Application Ref: 2022/1275 **Address:** 301 Barnsley Road, Hoylandswaine, Sheffield, S36 7JA

Demolition of shed and erection of new garden room

Proposed Elevations

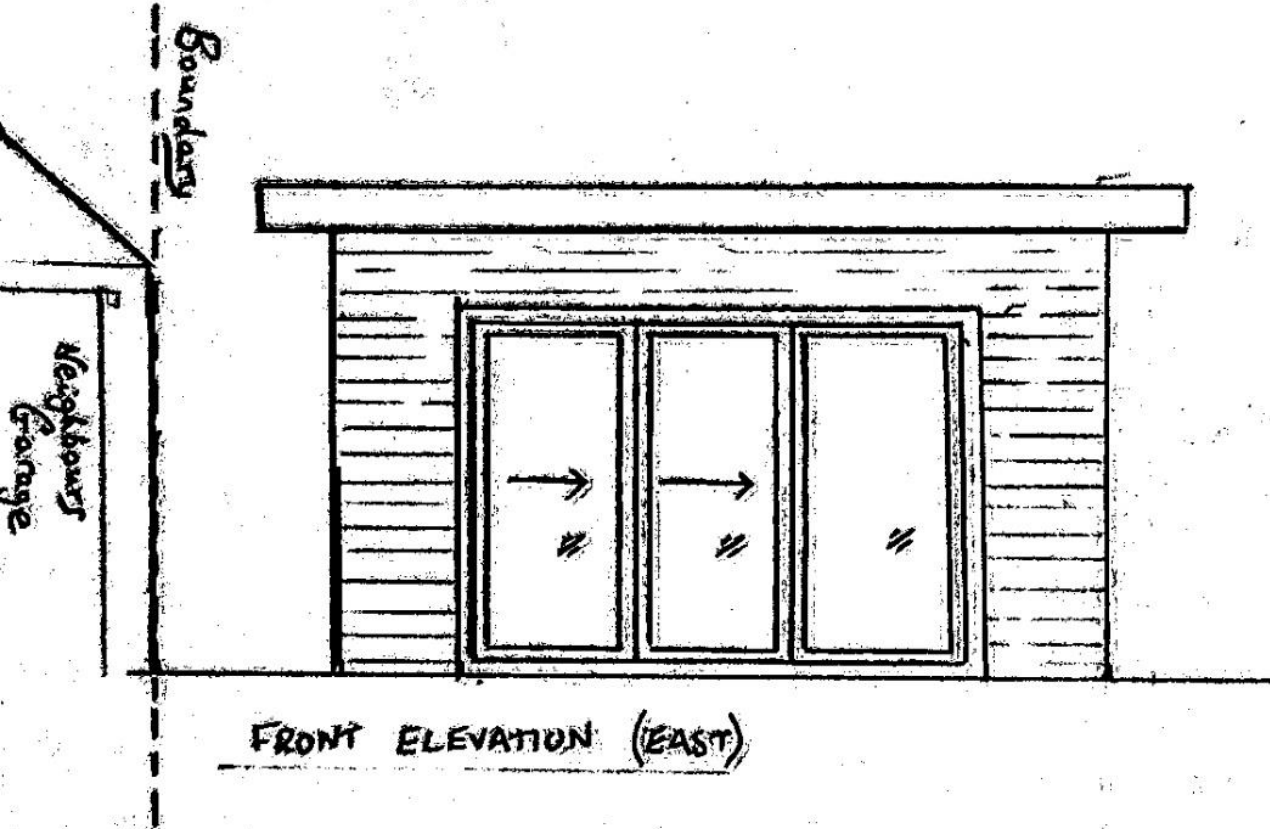
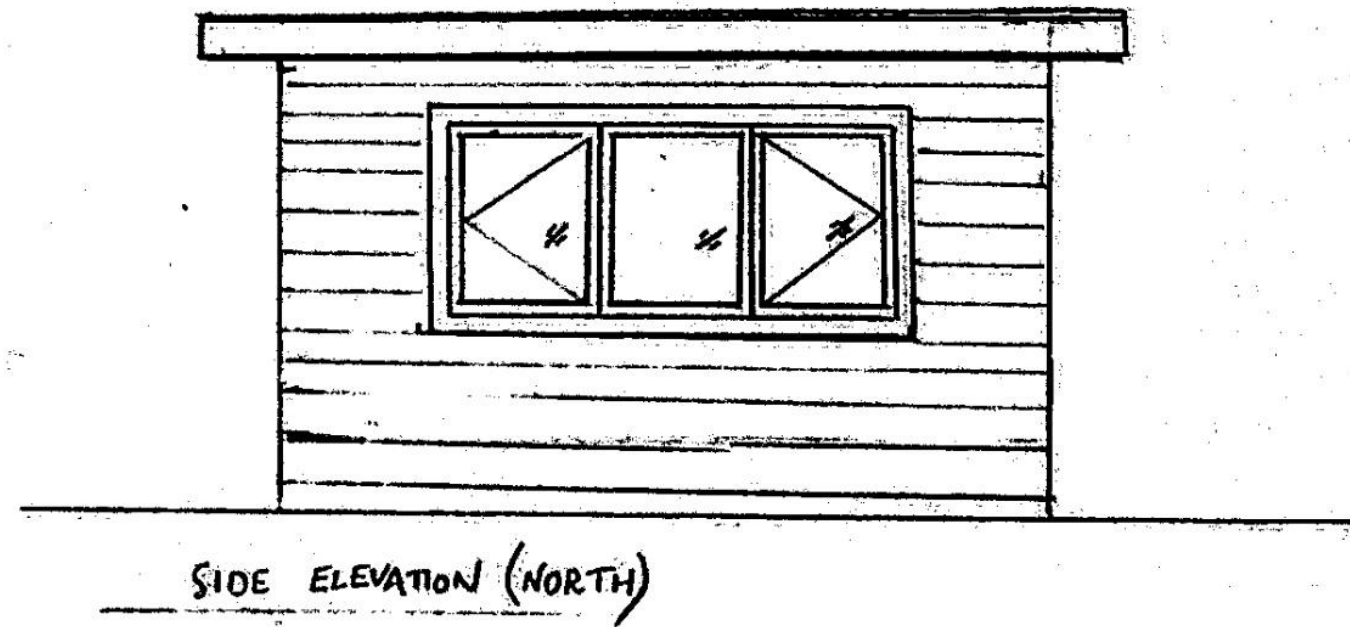
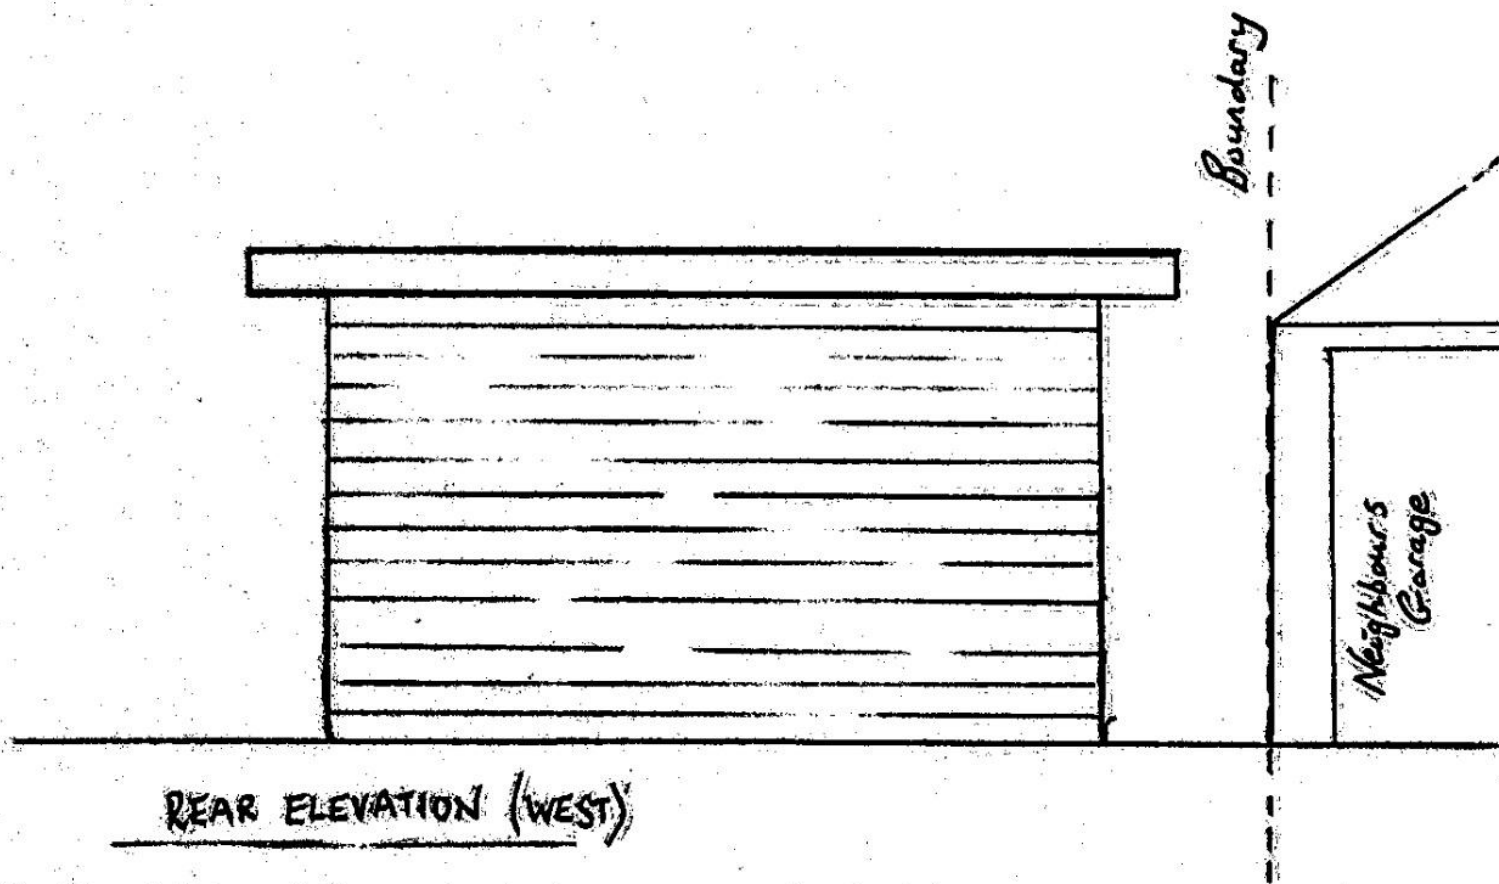
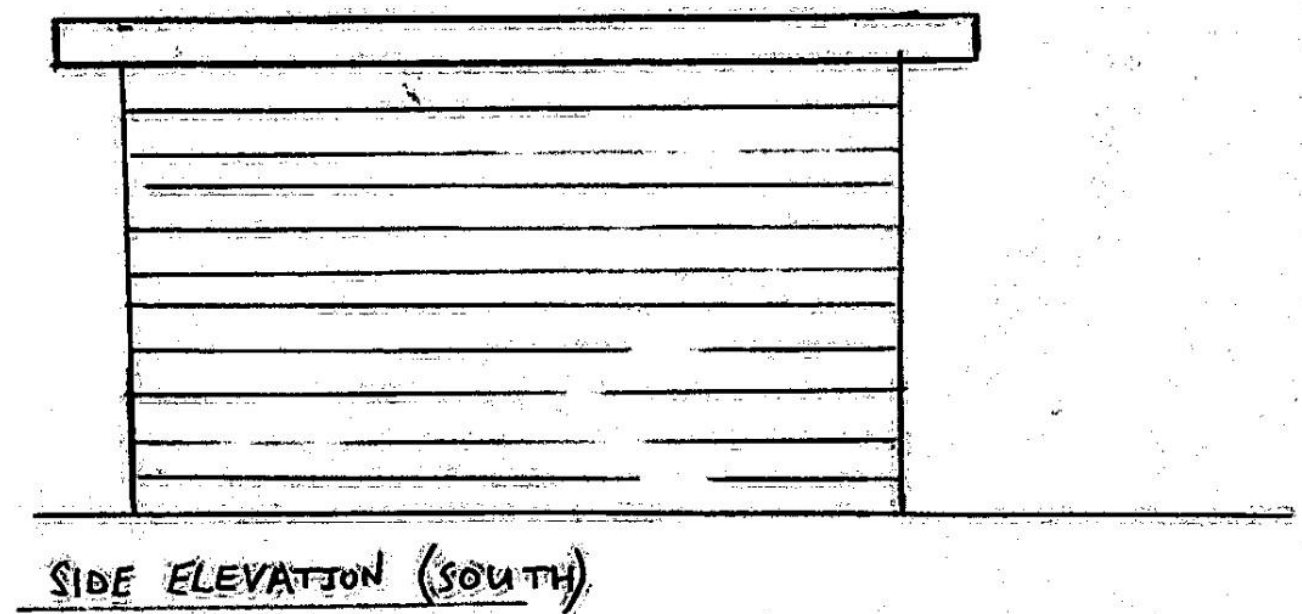
A statement was produced by the conservation team, stating the proposed development would not have a detrimental effect within the conservation area but it should not be too high and that subtle colour choices should be made to reduce its visual impact. Overall, no reason not to grant permission.

Although the proposed developments roof and eaves height are higher than what may usually be considered near the boundaries, mitigation arises from the provision of a flat roof and high existing boundary treatments. The proposed flat roof assist in maintaining an overall lower height as required by the conservation team. The proposed development is within 2 meters of the of the southern boundary with No. 297 Barnsley Road, but it would be adjacent to a blank elevation of the neighbour's taller detached garage. The proposed development may just breach the 2m boundary rule at the western boundary with No. 2 Hall Farm Grove but there is an existing high hedge boundary, so the proposed development would not adversely impact on No 2.

Site plan: proposed

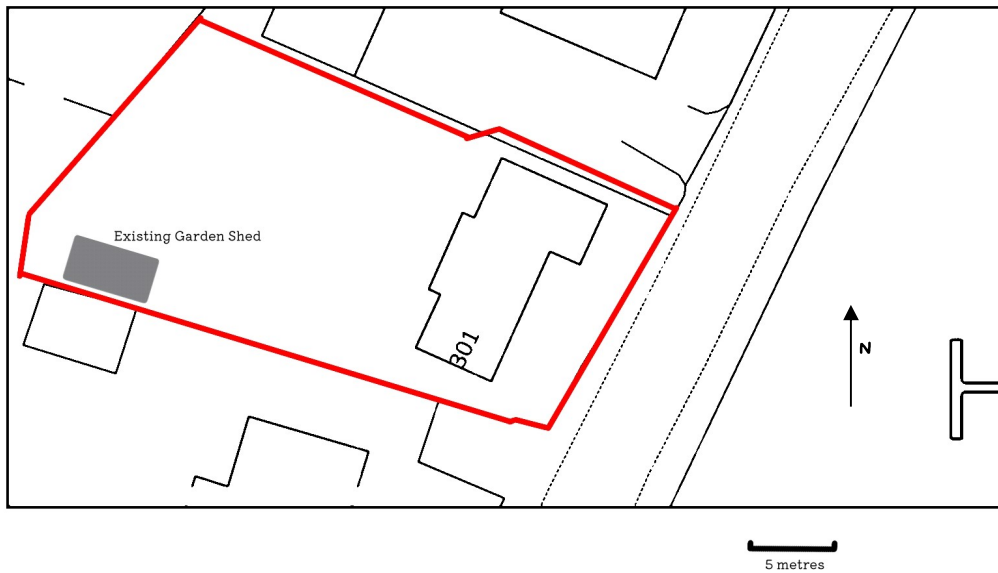
The overall curtilage of the dwelling is of a very generous size and there is no information recorded or provided about existing extensions or outbuildings within the dwelling's curtilage. The proposed development would only require a little more area of garden land than the existing structure

currently occupies. Furthermore, the structure would use the existing foundation and, as required by the Forestry Officer, any development would have to provide information on how the development would protect the existing tree, prior to commencing.
